BR/50/20/L

Culver Cottage 37 Aldwick Road Bognor Regis PO21 2LN

Listed building consent to install a wood burner to the ground floor extension that will enter the existing listed chimney stack at first floor level & project flue top cap from existing stack from listed roof.

SECTION C-C
Dwg. No. 599-211

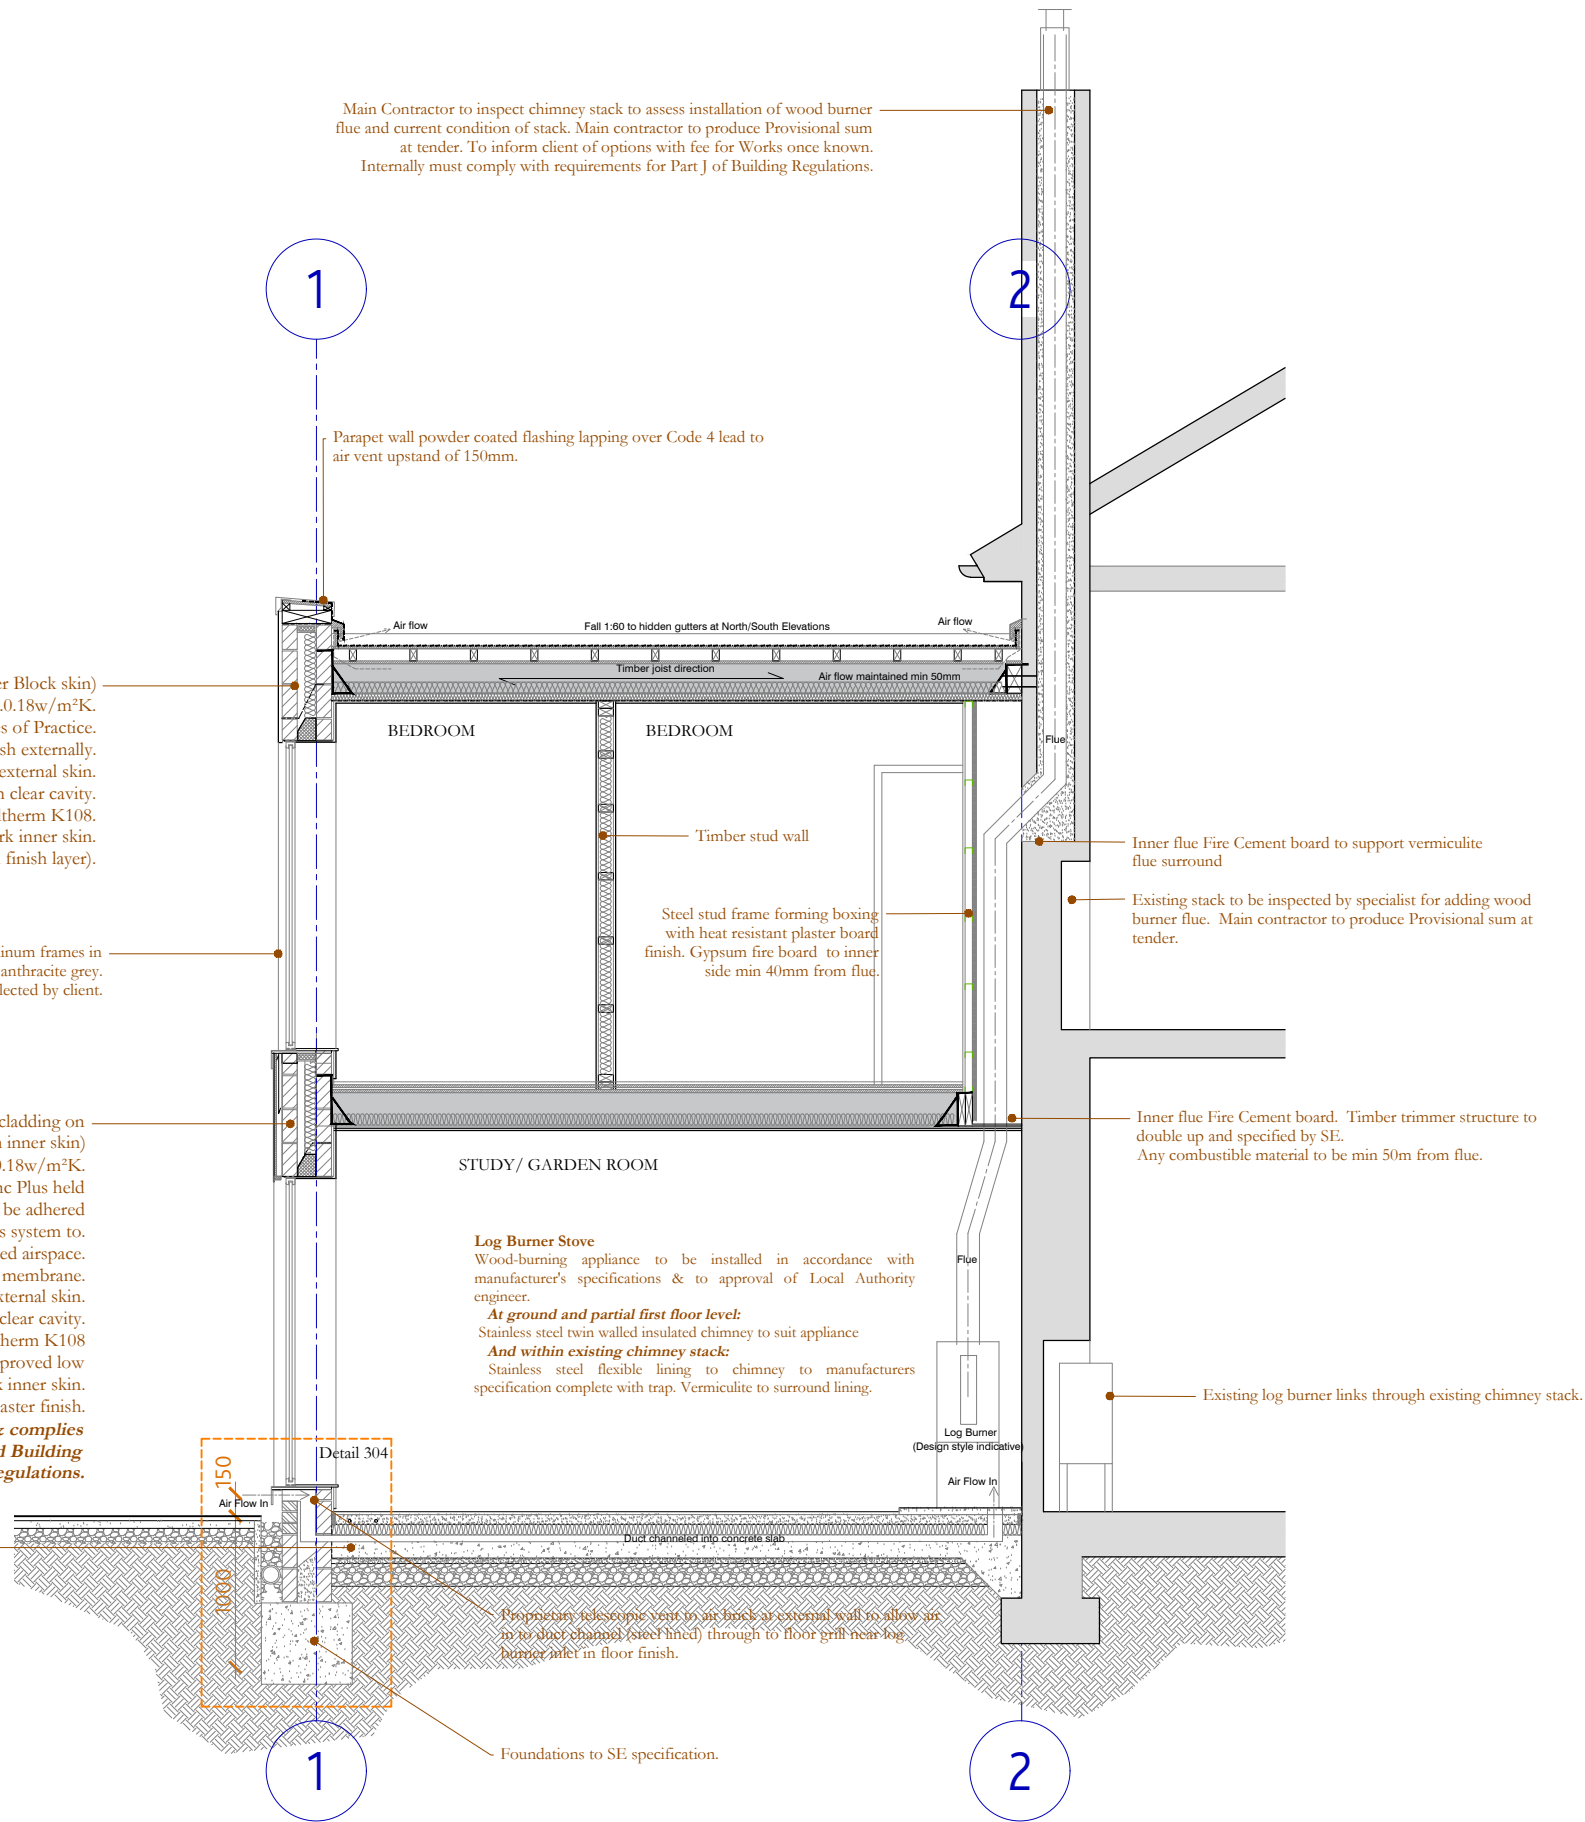
A wood burner would be located in the ground floor extension with the flue pipe utilising the existing buildings masonry stack at first floor level. The only portion externally visible will be the top metal capping to the wood burner flue at the top of the chimney stack.

If the opening into the existing masonry stack is limited to that which is necessary, it is considered that this element of the proposal is acceptable. The colour of the top metal capping will be key and should be painted so that it is not easily visible from the street.
